STATE OF NORTH CAROLINA
DEPARTMENT OF TRANSPORTATION

March 17, 2009

Subject: **Revision to the Applications for Section 404 Individual Permit, Section 401 Water Quality Certification, and Tar-Pamlico Buffer Authorization** for the extension of SR 1537 (Daniel Street) from SR 1518 (Baker Street) to US 258, Tarboro, Edgecombe County. State Project No. 8.2291201, WBS 34983.1.1, TIP No. U-3826.

Reference: Individual Application dated February 4, 2009

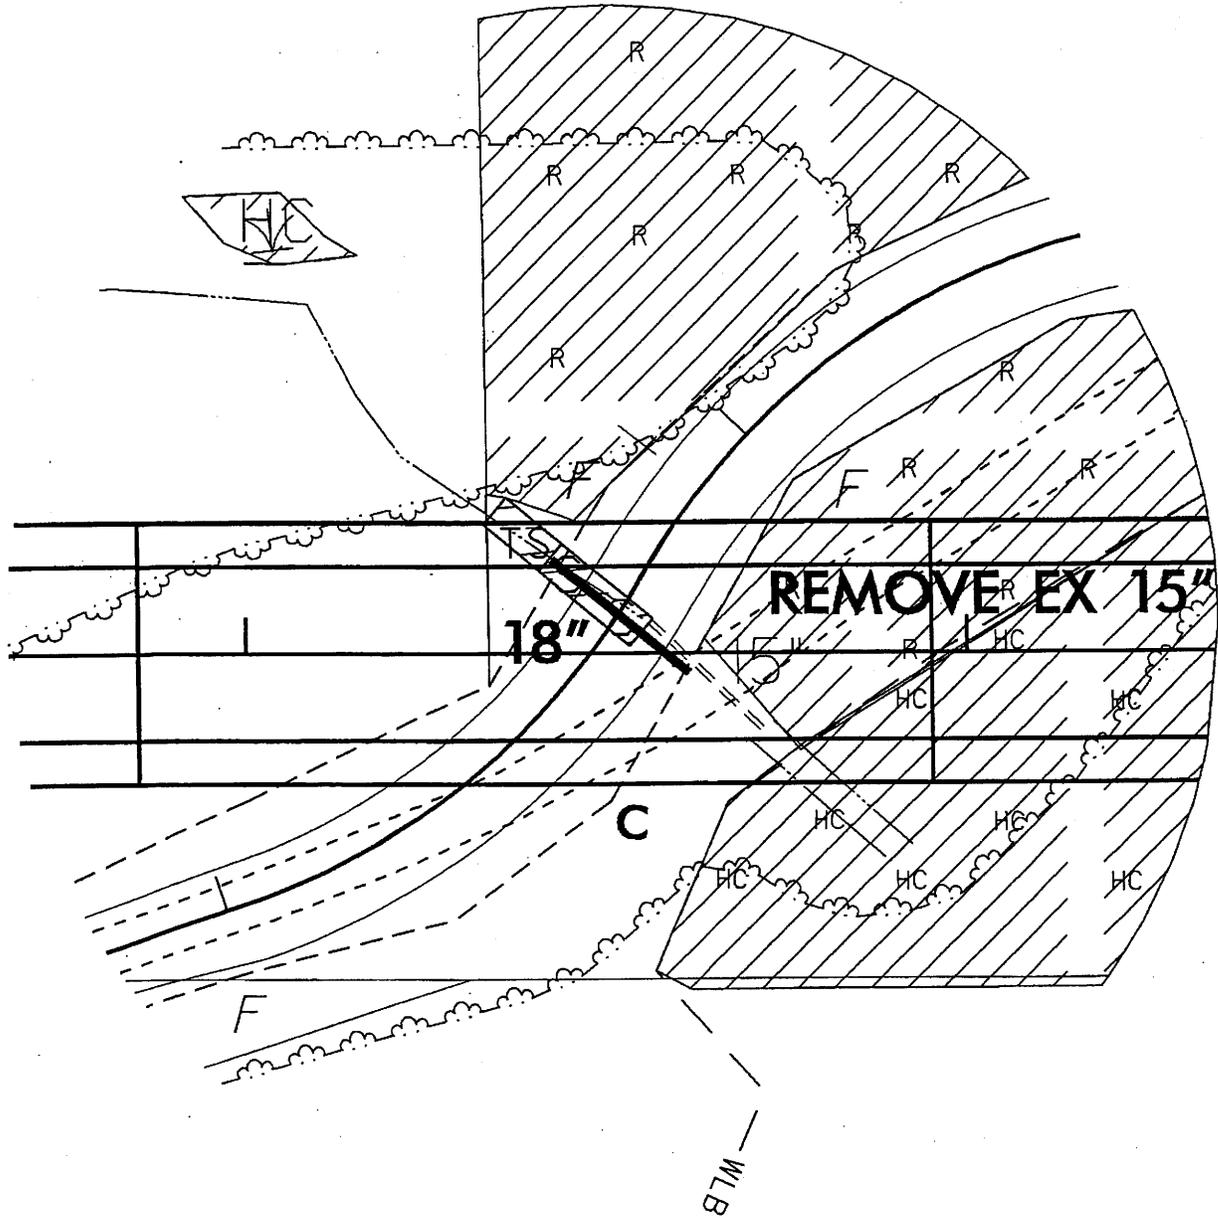
Revisions to the Compensation section (12.2) have also occurred. Changes are noted in bold in the following paragraphs.

NCDOT proposes to restore 0.86 acre of riparian wetland for this project (see the wetland drawings and Daniel Street Extension Wetland Restoration Plan for details). The remaining 0.62 acre of wetland will be offset with assets from the Mildred Wood Mitigation Site.

WETLAND PERMIT IMPACT SUMMARY

NOTE: SITE 3 RESTORATION OF WETLAND=0.86 ACRES

Site No.	Station (From/To)	Structure Size / Type	WETLAND IMPACTS						SURFACE WATER IMPACTS					
			Permanent Fill In Wetlands (ac)	Temp. Fill In Wetlands (ac)	Excavation in Wetlands (ac)	Mechanized Clearing in Wetlands (ac)	Hand Clearing in Wetlands (ac)	Permanent SW Impacts (ac)	Temp. SW Impacts (ac)	Existing Channel Impacts Permanent (ft)	Existing Channel Impacts Temp. (ft)	Natural Stream Design (ft)		
1	34+50/36+50	ROADWAY FILL	0.71			0.04								
2	40+15/41+00	ROADWAY FILL	0.04											
3	44+00/46+00	BRIDGE CONSTRUCTION					0.23							
4	57+10/59+65	ROADWAY FILL	0.61	0.23		0.08	0.62		0.01	0.01	16	10		
TOTALS:			1.36	0.23		0.12	0.85		0.01	0.01	16	10

Revised 3/6/09
